15 December 2016
Our Ref: N26522
Your Ref: DA 485-12-2002 MOD 1

**REQUEST TO MODIFY A DEVELOPMENT APPROVAL UNDER SECTION 75W OF THE EP&A ACT _
DEVELOPMENT APPLICATION 485-12-2002 MOD 1 - MODIFICATION TO RESIDENTIAL SUBDIVISION AT
NADINE STREET, SANCTUARY POINT**

Comments on Agency & Public Submissions

M:\Projects\20000\26522\Drawings\26522-406-TREES RETAINED.dwg

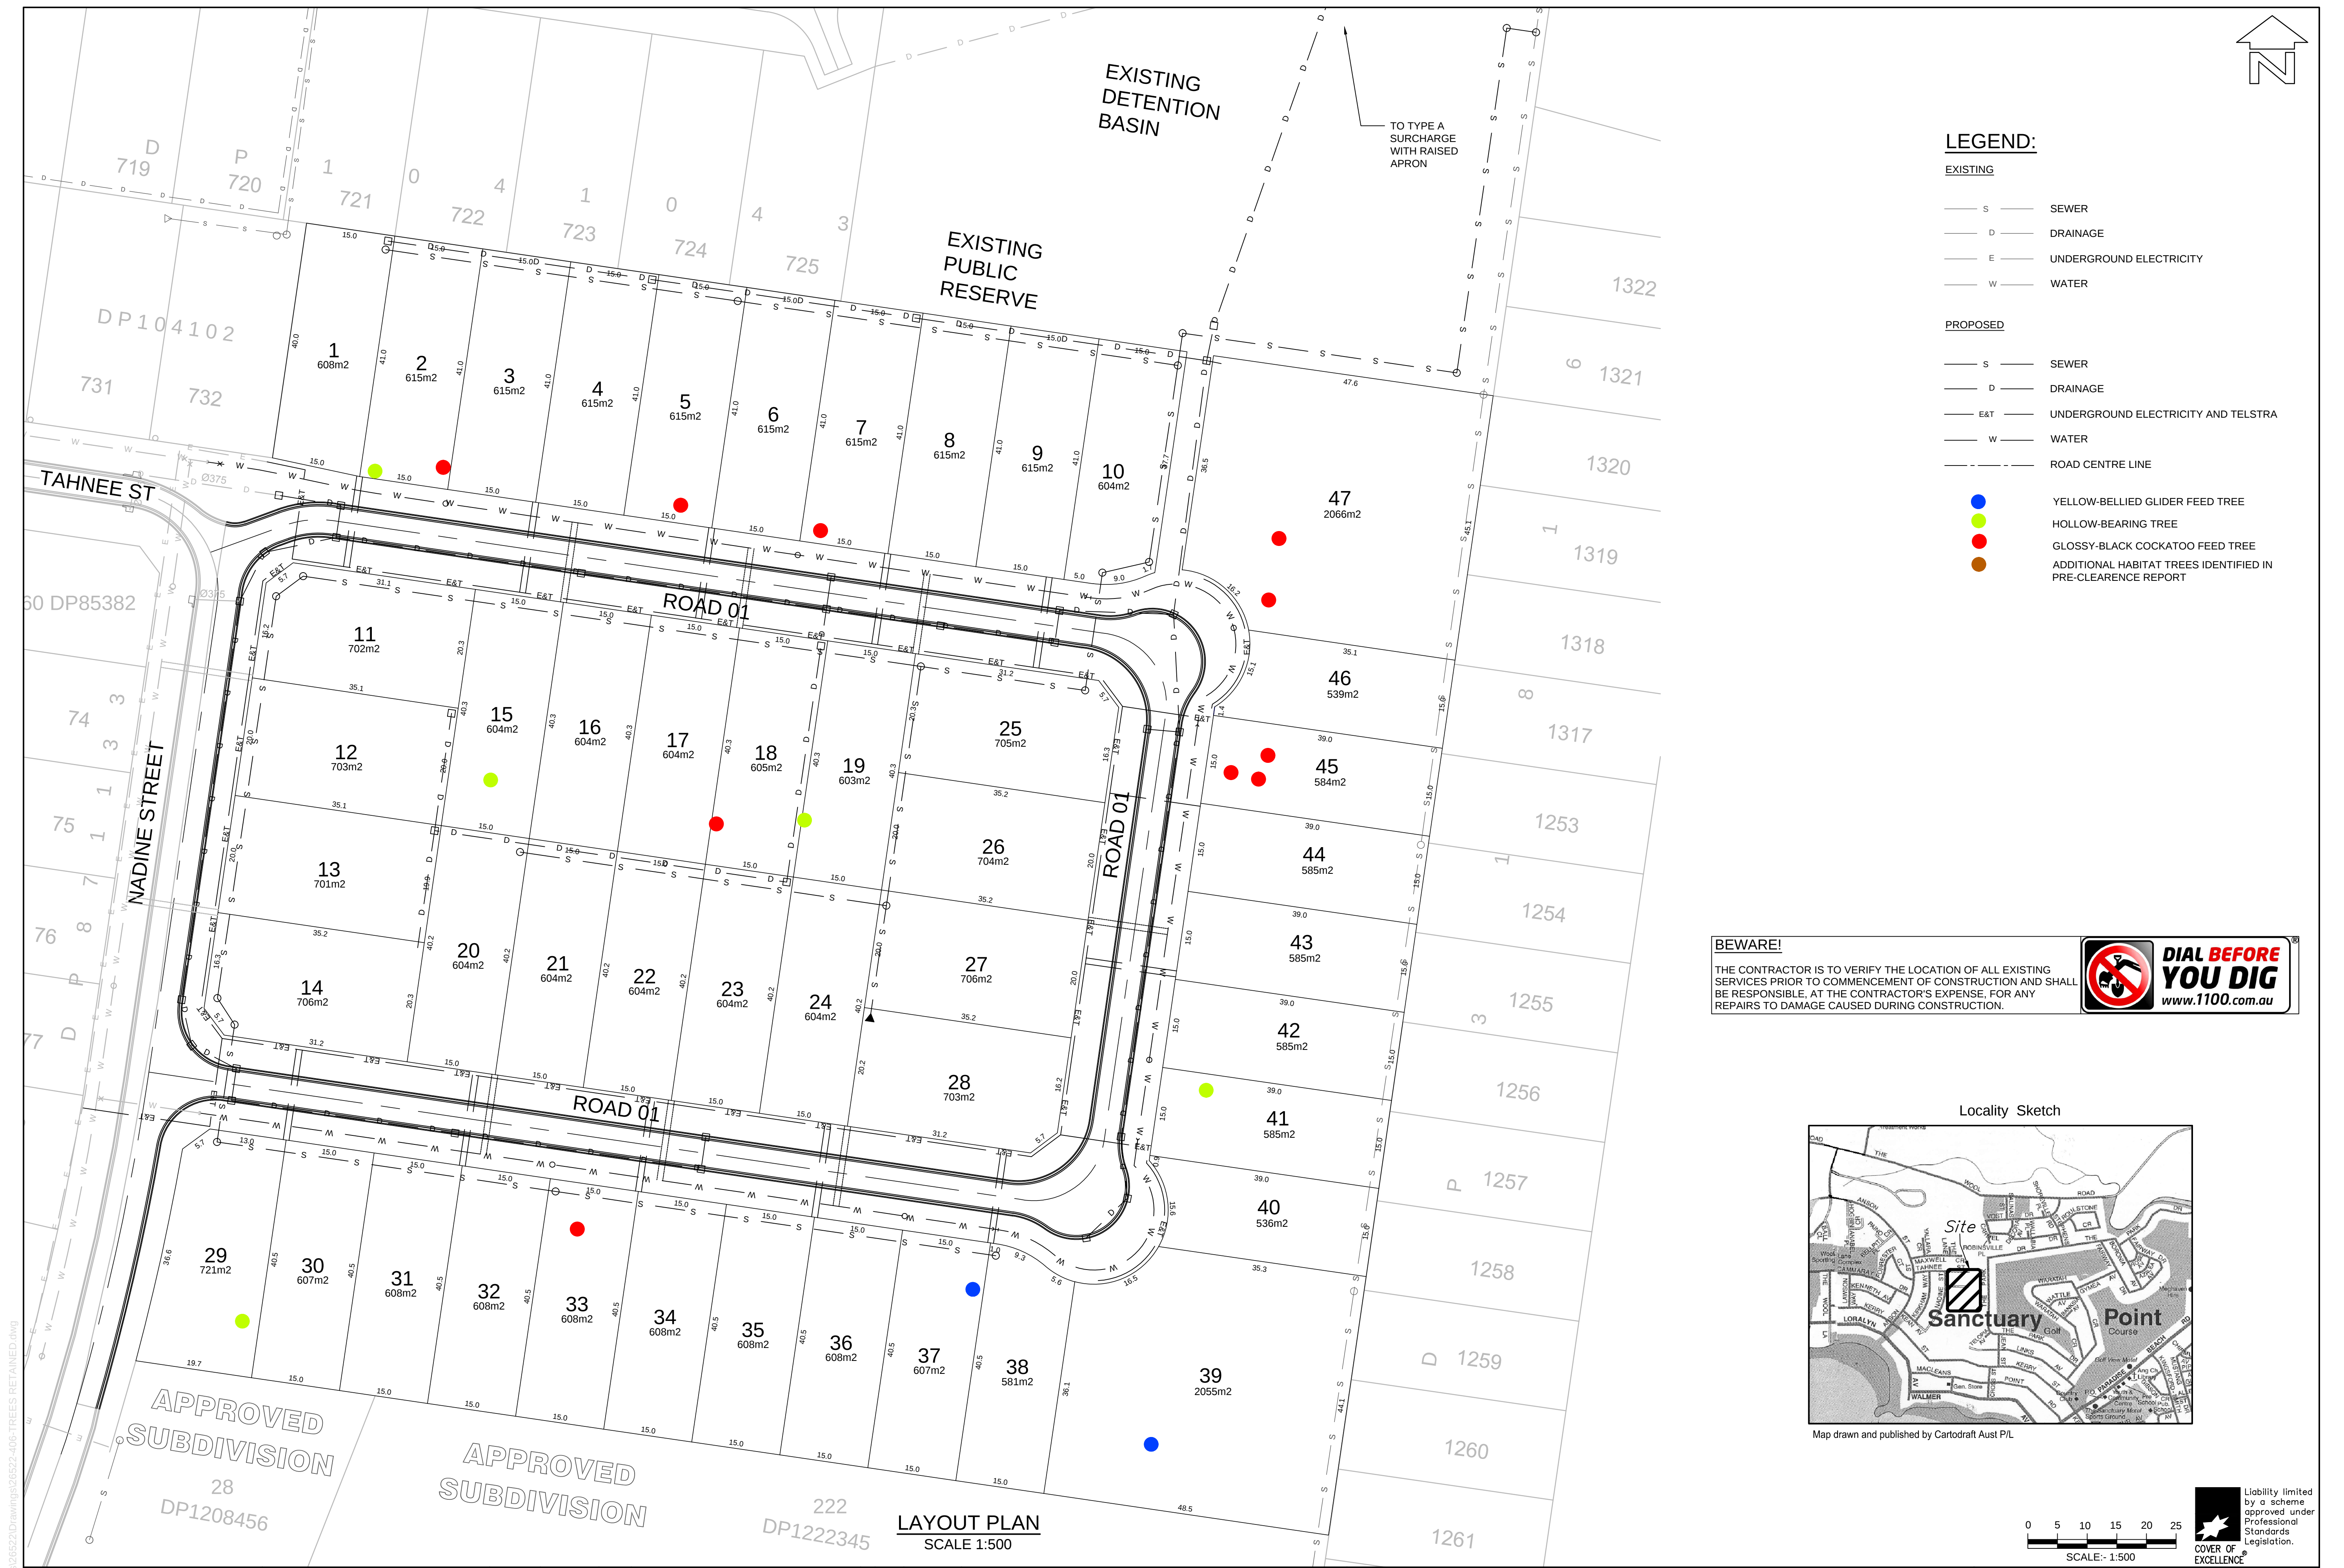
Agency	Detail of Issue	Response to Submission
	<p>2. Are not suited to the retention of trees;</p> <p>3. The removal of trees identified for retention has not been assessed.</p> <p>• Drainage - Deletion of the detention basin is to be compensated for by way of On-site Detention (OSD). Calculations for OSD demonstrating the effectiveness and application of this strategy have not been provided.</p>	<ul style="list-style-type: none"> • The removal of trees shall take place in accordance with approved development consent no. 485-12-2002. Impacts associated with tree removal were assessed within the original development application and the site has been cleared with the exception of a few habitat trees in accordance with this consent. Council should be very aware that residential development and large trees are generally mutually exclusive. • In accordance with development consent no. 485-12-2002, <i>“all trees identified on the lot survey plan for retention are to be retained for the purposes of habitat, except in the case that they present a real and significant risk to life, limb or property”</i>. <p>In order to preserve native flora and fauna and provide an opportunity for tree retention, it is not proposed to remove trees identified for retention as a component of this S75W. Therefore the removal of trees identified to be retained will not take place, unless an updated vegetation clearance and retention plan is approved by Planning NSW.</p> <p>A plan accompanying this response detailing trees proposed to be retained and the new lot layout, confirms that there is no conflict with trees marked to be retained and proposed future dwelling sites.</p> <ul style="list-style-type: none"> • OSD has been detailed within an attached report demonstrating the effectiveness and application of the strategy for OSD proposed for the site. <p>An email from Ian Dollery from Shoalhaven City Council to Allen Price and Scarratts, dated 18 August 2016, states Council’s position of no objection to replacing the detention basin on the</p>

Agency	Detail of Issue	Response to Submission
	<p>location of serves and landscaping have not been provided.</p> <ul style="list-style-type: none"> • Consideration should be provided to additional onsite parking as the smaller streets have the ability to create congestion. • Vegetation Removal - A vegetation retention plan has been approved and is being carried out under Council Construction Certificate CC16/1533. The vegetation retention plan identifies trees within the currently approved lots. The density of the proposal has increased from 39 lots to 51 lots, i.e. 23.5% increase in lots. In addition, the average lot size of the approved development is 723m² without access handles. The average lot size in the proposed modification is 642m² (without access handles) with 82% of the lots having a reduced lot width of 15m. <p>The size and width of lots in the proposed modification provides very limited opportunity to retain any of the trees identified for retention in the vegetation retention plan. Furthermore, Council does not support deferring the cost of development, that is, tree</p>	<p>Response to Submission</p> <ul style="list-style-type: none"> • The proposed allotments are a minimum of 20% in excess of the minimum lot size of 500m². Numerous home builders with suitable single storey two-garage designs are available to fit on rectangular lots with 15m lot widths. Appropriately designed dwellings with ample car-parking can be adequately through the Development Application or Complying Development stage. • As previously stated, In accordance with development consent no. 485-12-2002, <i>“all trees identified on the lot survey plan for retention are to be retained for the purposes of habitat, except in the case that they present a real and significant risk to life, limb or property”</i>. <p>In order to preserve native flora and fauna and provide an opportunity for tree retention, it is not proposed to remove trees identified for retention as a component of this S75W. Therefore the removal of trees identified to be retained will not take place, unless an updated vegetation clearance and retention plan is approved by Planning NSW.</p> <p>A plan accompanying this response detailing trees proposed to be retained and the new lot layout, confirms that there is no conflict with trees marked to be retained and proposed future dwelling sites.</p> <ul style="list-style-type: none"> • A more recent Vegetation Clearance and Retention Plan has been approved by Chris Ritchie from Planning NSW, as confirmed in an email dated 2 September 2016.

Agency	Detail of Issue	Response to Submission
	<p>removal, to the future land owner. The current approval and the associated vegetation retention plan relied upon the 'Flora and Fauna Assessment' dated October 2002 by Gunninah Environmental Consultants. Given the significant lapse in time since the initial assessment, i.e. 14 years, removal of vegetation identified in the vegetation retention plan should be subject to a further assessment of significance.</p> <ul style="list-style-type: none"> • Contributions – Council has detailed the estimated contribution fees associated with the development for the 2016/2017 financial year. • Shoalhaven Water – Shoalhaven Water has detailed requirements relating to the proposed development. • Overshadowing - The properties orientated east west (lots 39 - 51) will need to be provided with setbacks from the southern boundaries to reduce the impact of overshadowing for two storey development. • And Or the following 88B restriction may need to be considered: <ul style="list-style-type: none"> a) The average building setback for the residential section of the building shall not be less than 	<ul style="list-style-type: none"> • It is acknowledged that the payment of applicable contributions is required at the appropriate stage. • It is acknowledged that compliance with the requirements of Shoalhaven Water is required for the proposed development. • Potential overshadowing can be addressed at dwelling application stage in accordance with the provisions of the Shoalhaven Local Environmental Plan (LEP) or the State Environmental Planning Policy (SEPP) (Exempt and Complying Development Codes 2008). <p>The listed restrictions proposed to be imposed on the 88B Instrument can be determined at dwelling application stage in accordance with the provisions of the Shoalhaven Local Environmental Plan (LEP) or the State Environmental Planning Policy (SEPP) (Exempt and Complying Development Codes 2008).</p>

A revised plan, titled Drawing number 26522-402; Sheet 1-2 of 2; Revision 1; details of On-Site-Detention and a plan detailing trees marked for retention accompanies this letter.
